# **The Northwood Action Group Inc**

### **Subject: Objection to Redevelopment of Greenwich Hospital (Amended Concept Proposal) SSD 8699 and Response to Submissions**

SHADOW DIAGRAMS

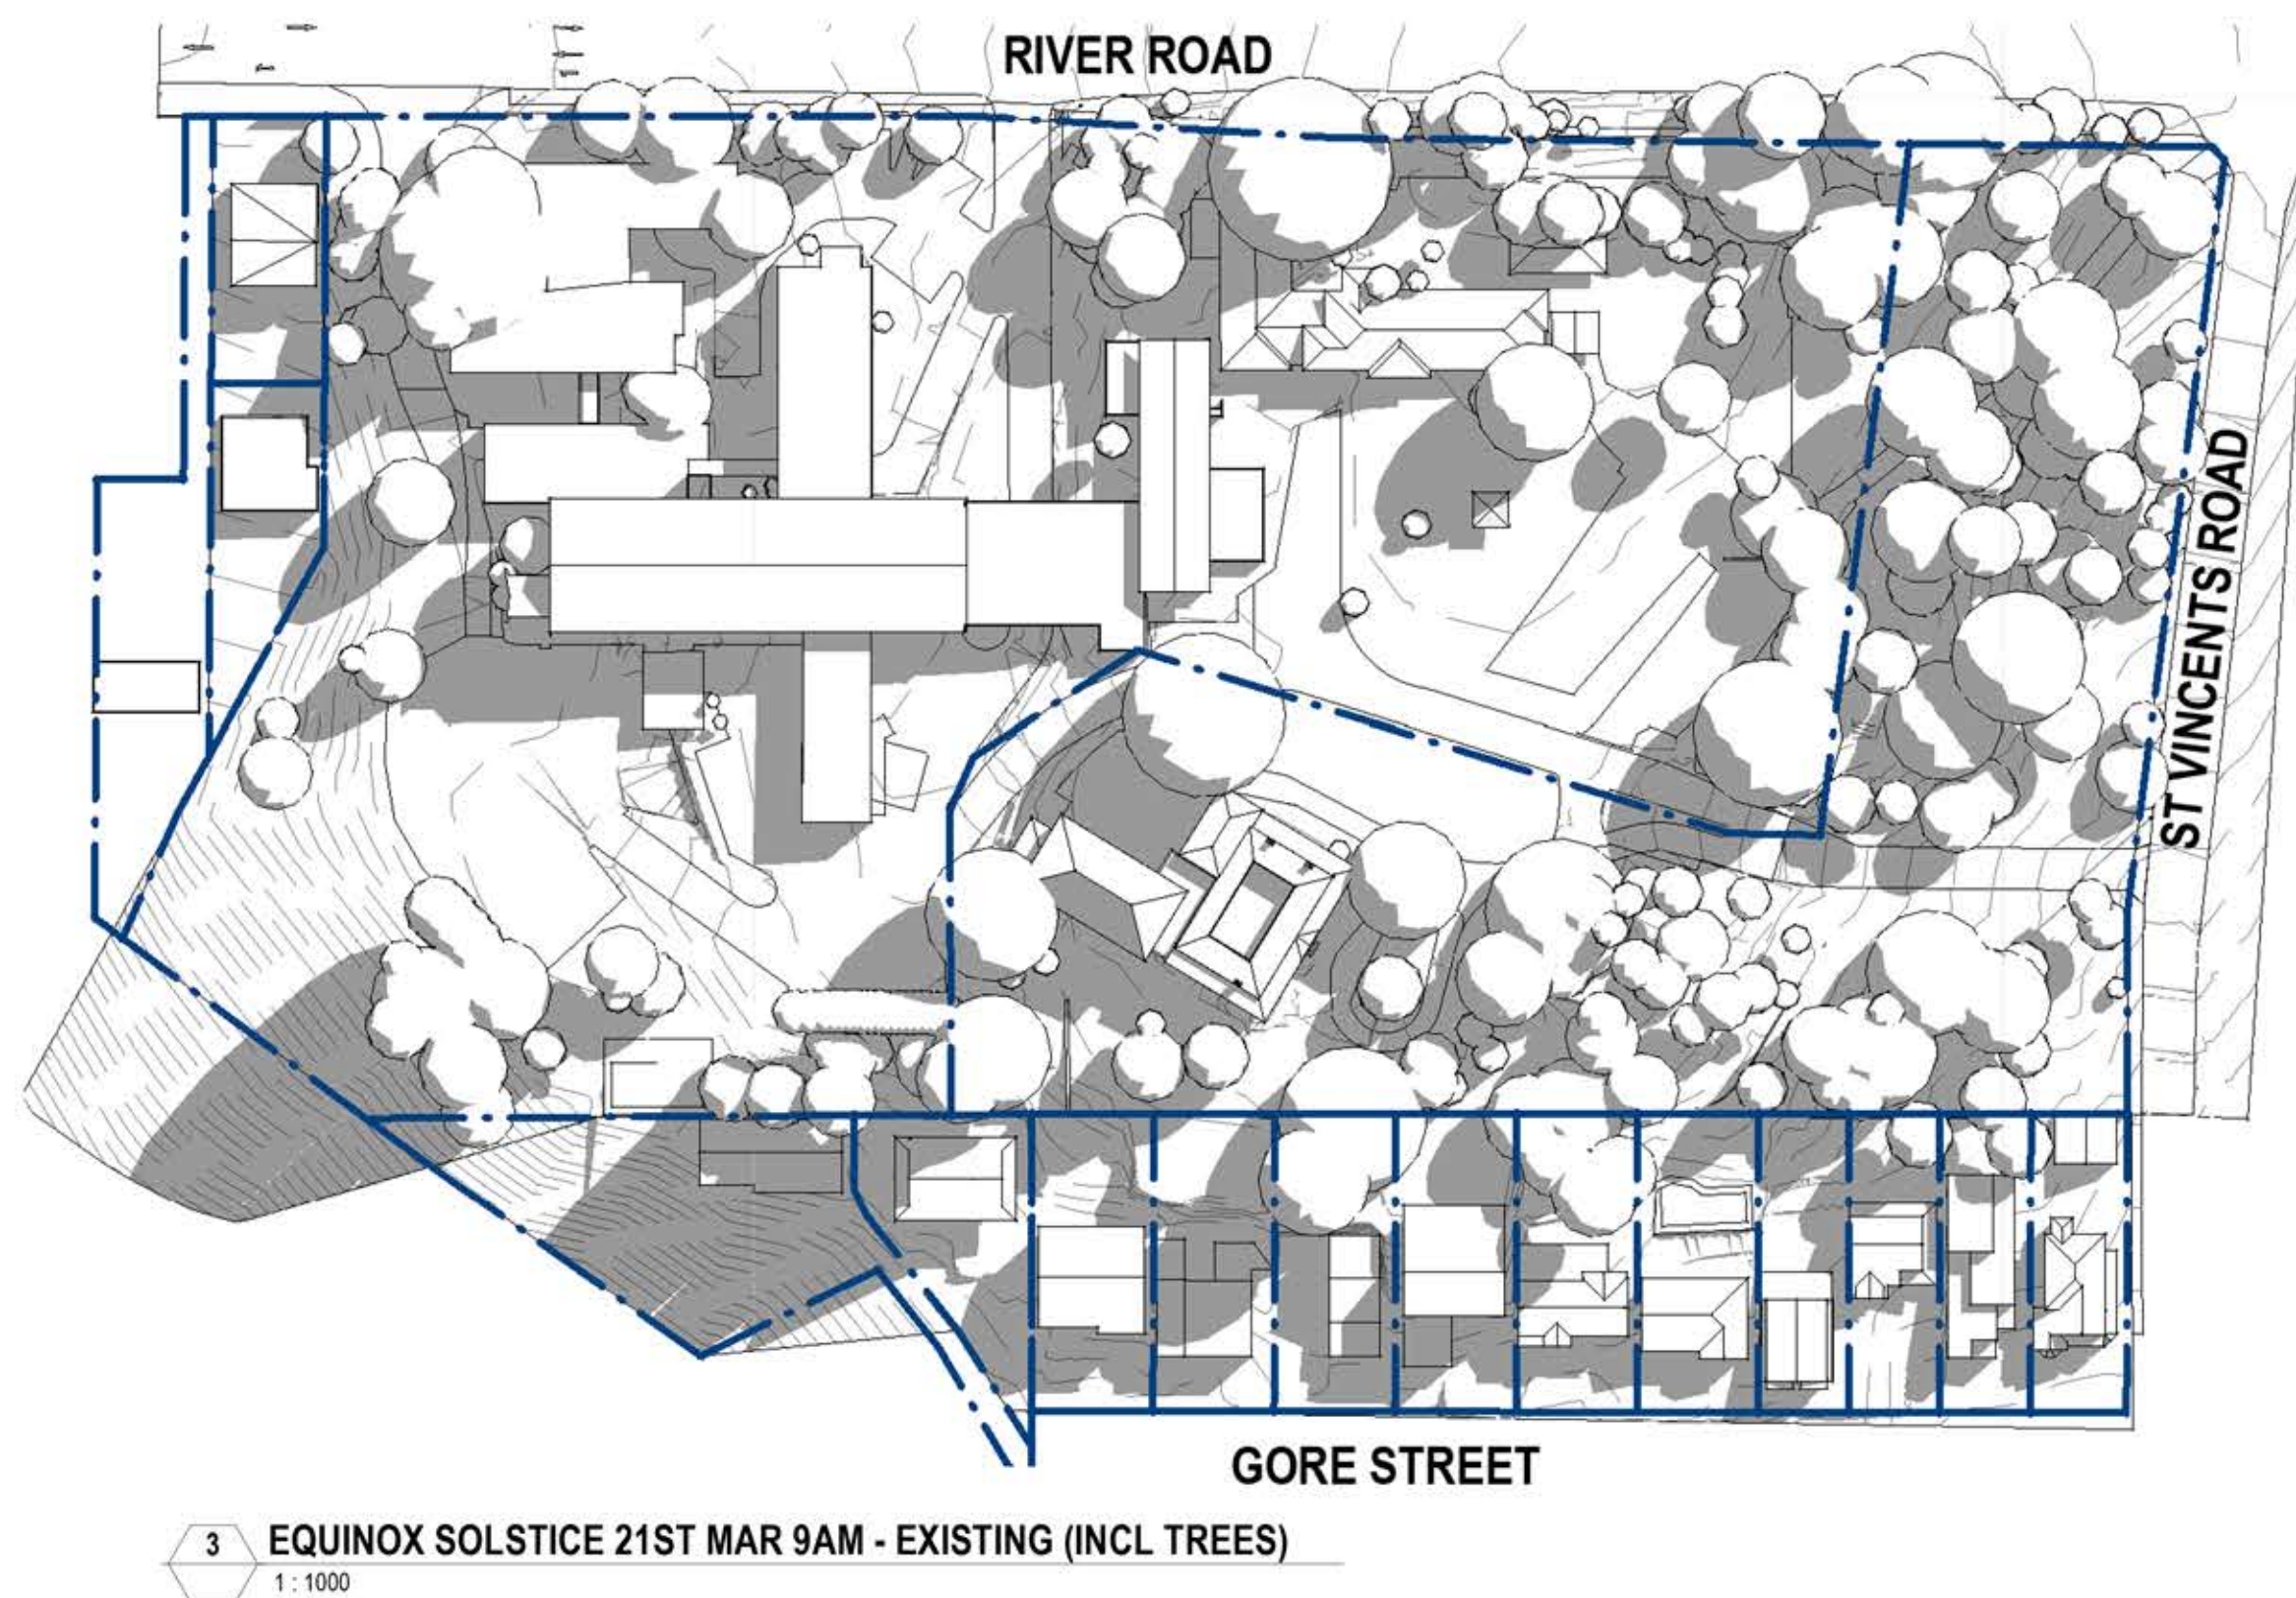
- incorrect shadow diagrams
- incorrect information on landscape
- no reliable tree survey in the bushland area
- bushfire report and information on which RFS has based its comments will be wrong
- incorrect hydraulic flow calculations
- trees (which are offered as future planting to "screen" the Seniors Living from Northwood) will not grow on cliffs, and if growing at the much lower level which is the reality on this south-western portion, will take a very long time to even reach the top of the cliff, let alone screen .

## 2.10 Riparian and Bushland zone

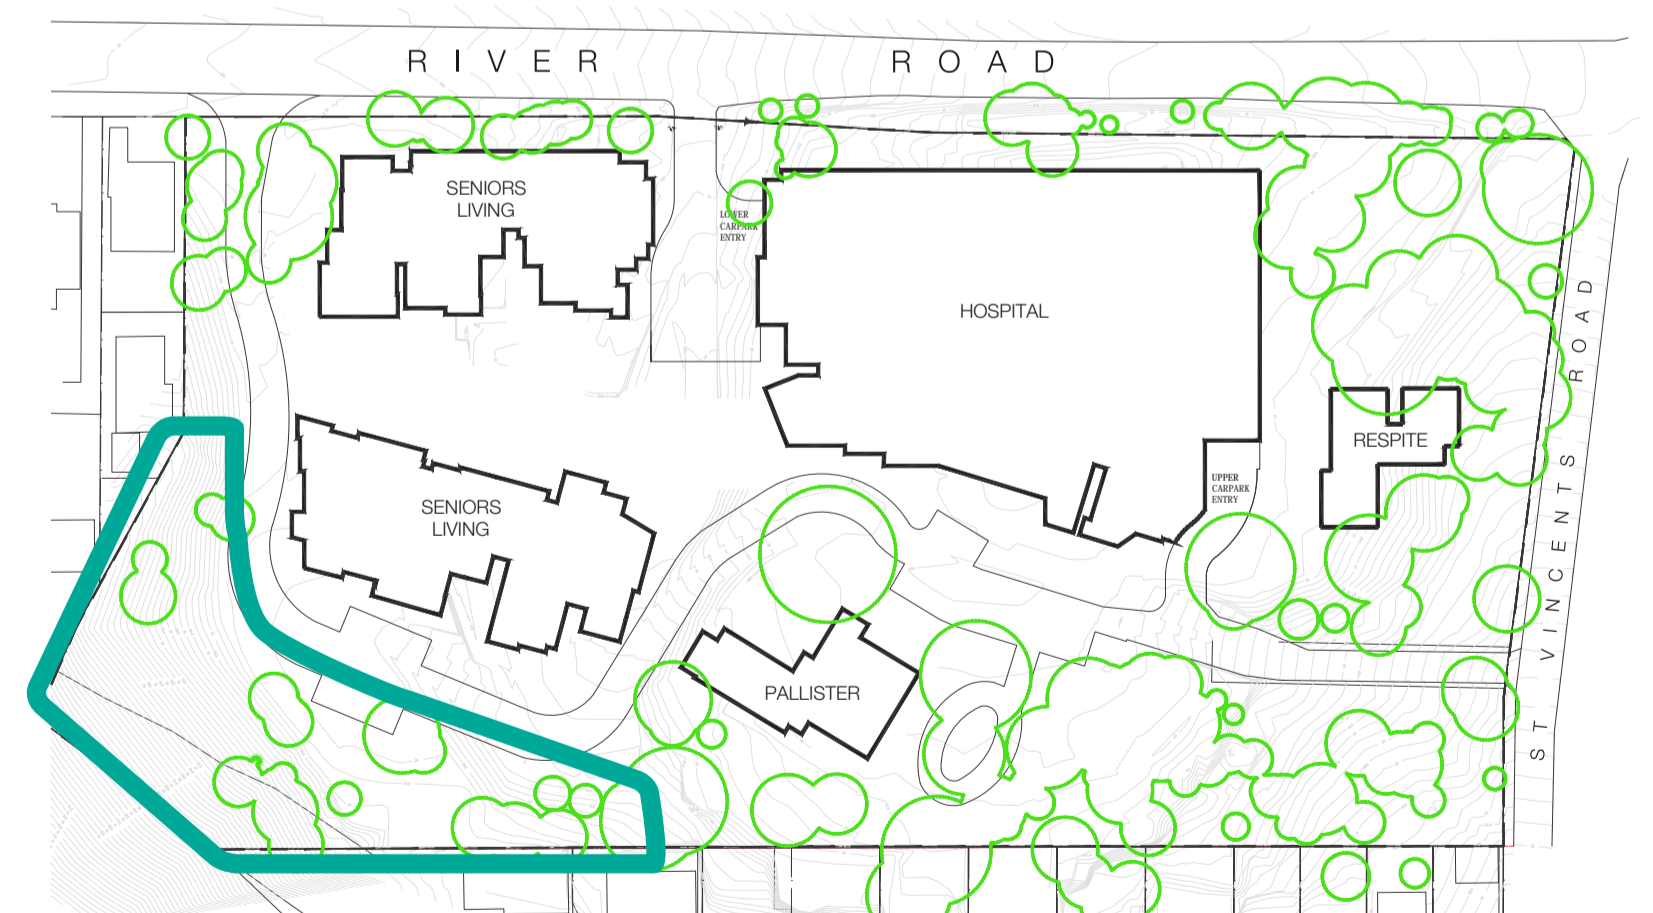
Below are extracts from p21 of Landscape. It ambitiously claims to be clearing weeds, planting new canopy trees where shown which are largely on steep rocky ground, , all the while having views across to Northwood and Lane Cove River. There is no clarification on which parts of the area are called "rainforest". At the same time, the tree plantings have to be spaced out so that as they grow the growing branches will stay as far apart as required to satisfy NSW Bushfire Guideline. This is not genuine Landscape plan at all, because the author does not know what is on the land, but has merely drawn marketing-style pretty pictures.

Above - extract from p21 of Landscape package is based on wrong information. There is a misguided idea that some of these trees will screen the Seniors Living from 46a Upper Cliff Rd, Northwood.
